Fire Marshal Division

RE: Harnett County Food Mart
4585 NC 210 N.
Lillington, NC 27546

Application Number FMFW2001-0002

DATE: 11/11/19
DWG.#: REG36
DRAWN BY: Jwylie36
SCALE: 3/4" = 1'-0"
MASTER DRAWING
SHEET NO. 1

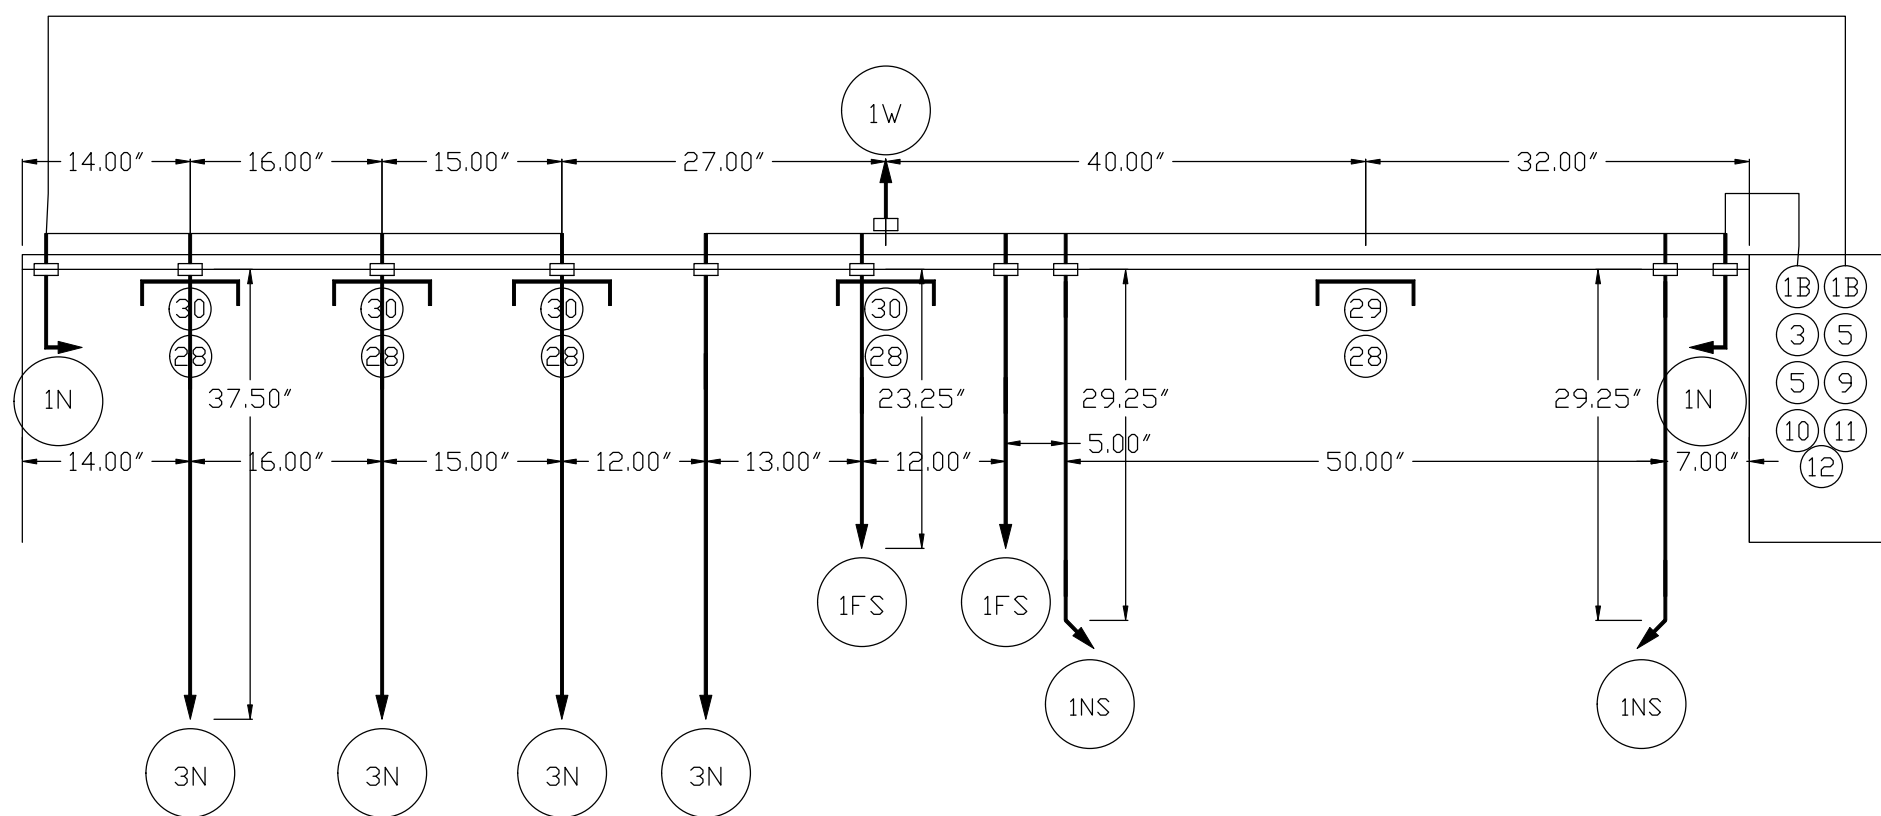
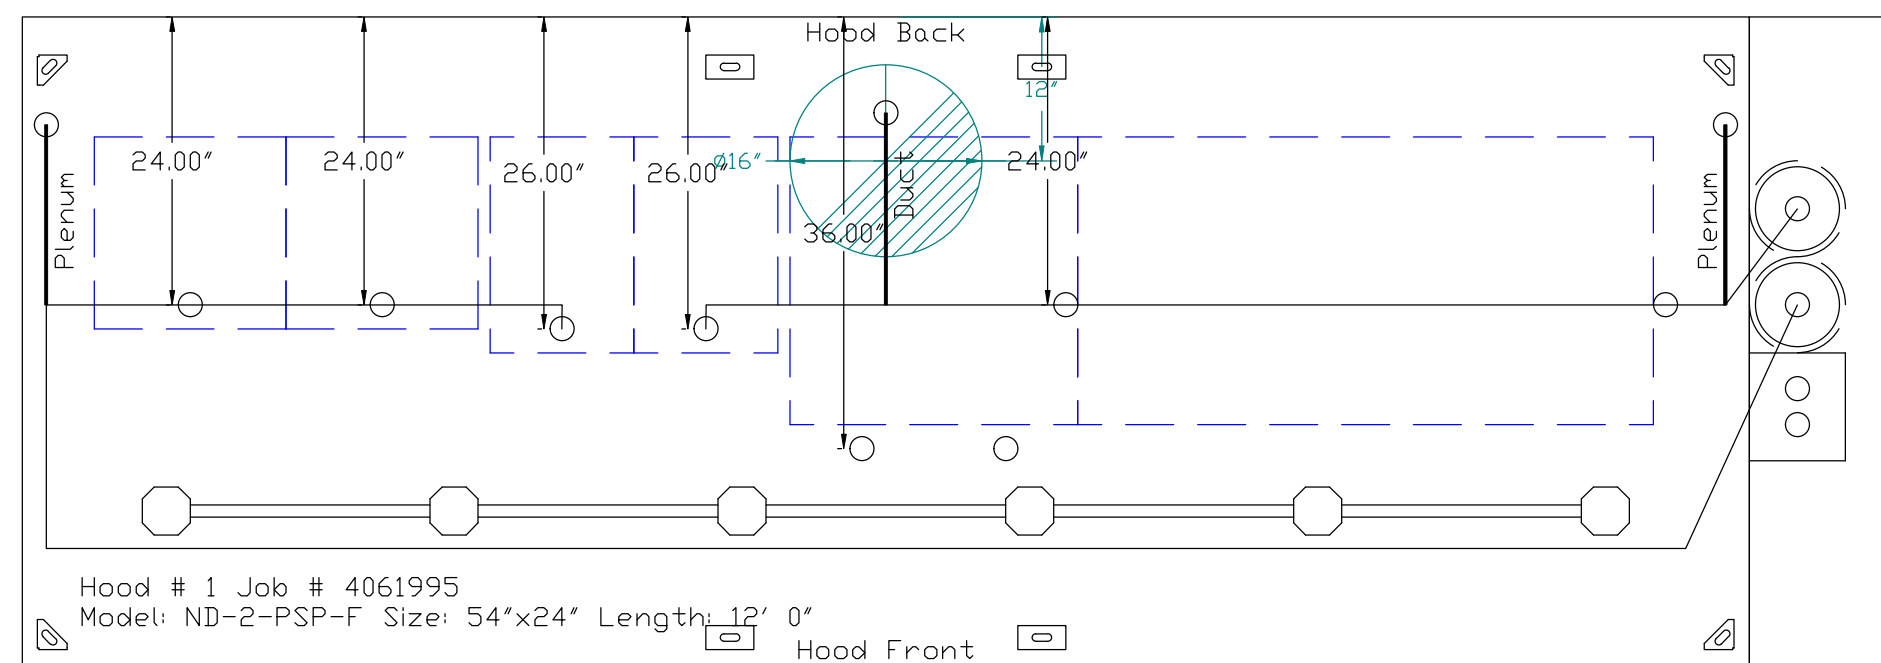
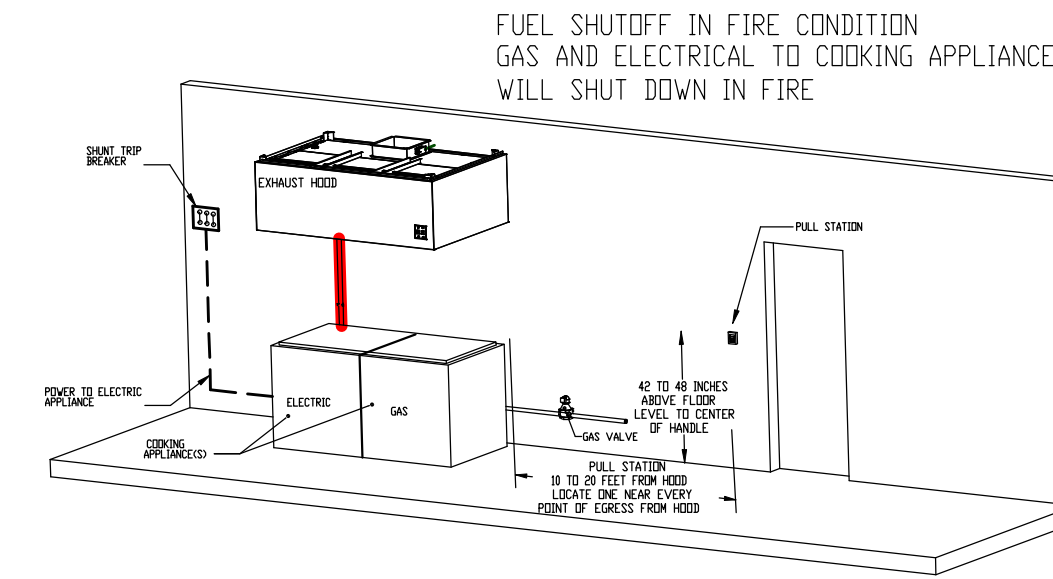
- **Commercial cooking equipment.**
 - Portable fire extinguishers shall be provided within a 30-foot (9144 mm) travel distance of commercial-type cooking equipment. Cooking equipment involving vegetable or animal oils and fats shall be protected by a Class K rated portable extinguisher.
- **Acceptance Test**
 - An acceptance test will be conducted by the Fire Marshal's office once system has been installed and pre-tested.
 - Installation shall be per architectural and system submittals and compliant with NFPA-17A.
- **Manual system operation**
 - A manual actuation device shall be located at or near a means of egress from the cooking area, a minimum of 10 feet (3048 mm) and a maximum of 20 feet (6096 mm) from the kitchen exhaust system. The manual

actuation device shall be located a minimum of 4.5 feet (1372 mm) and a maximum of 5 feet (1524 mm) above the floor. The manual actuation shall require a maximum force of 40 pounds (178 N) and a maximum movement of 14 inches (356 mm) to actuate the fire suppression system.

- The actuation of the fire suppression system shall automatically shut down the fuel or electrical power supply to the cooking equipment. The fuel and electrical supply reset shall be manual.
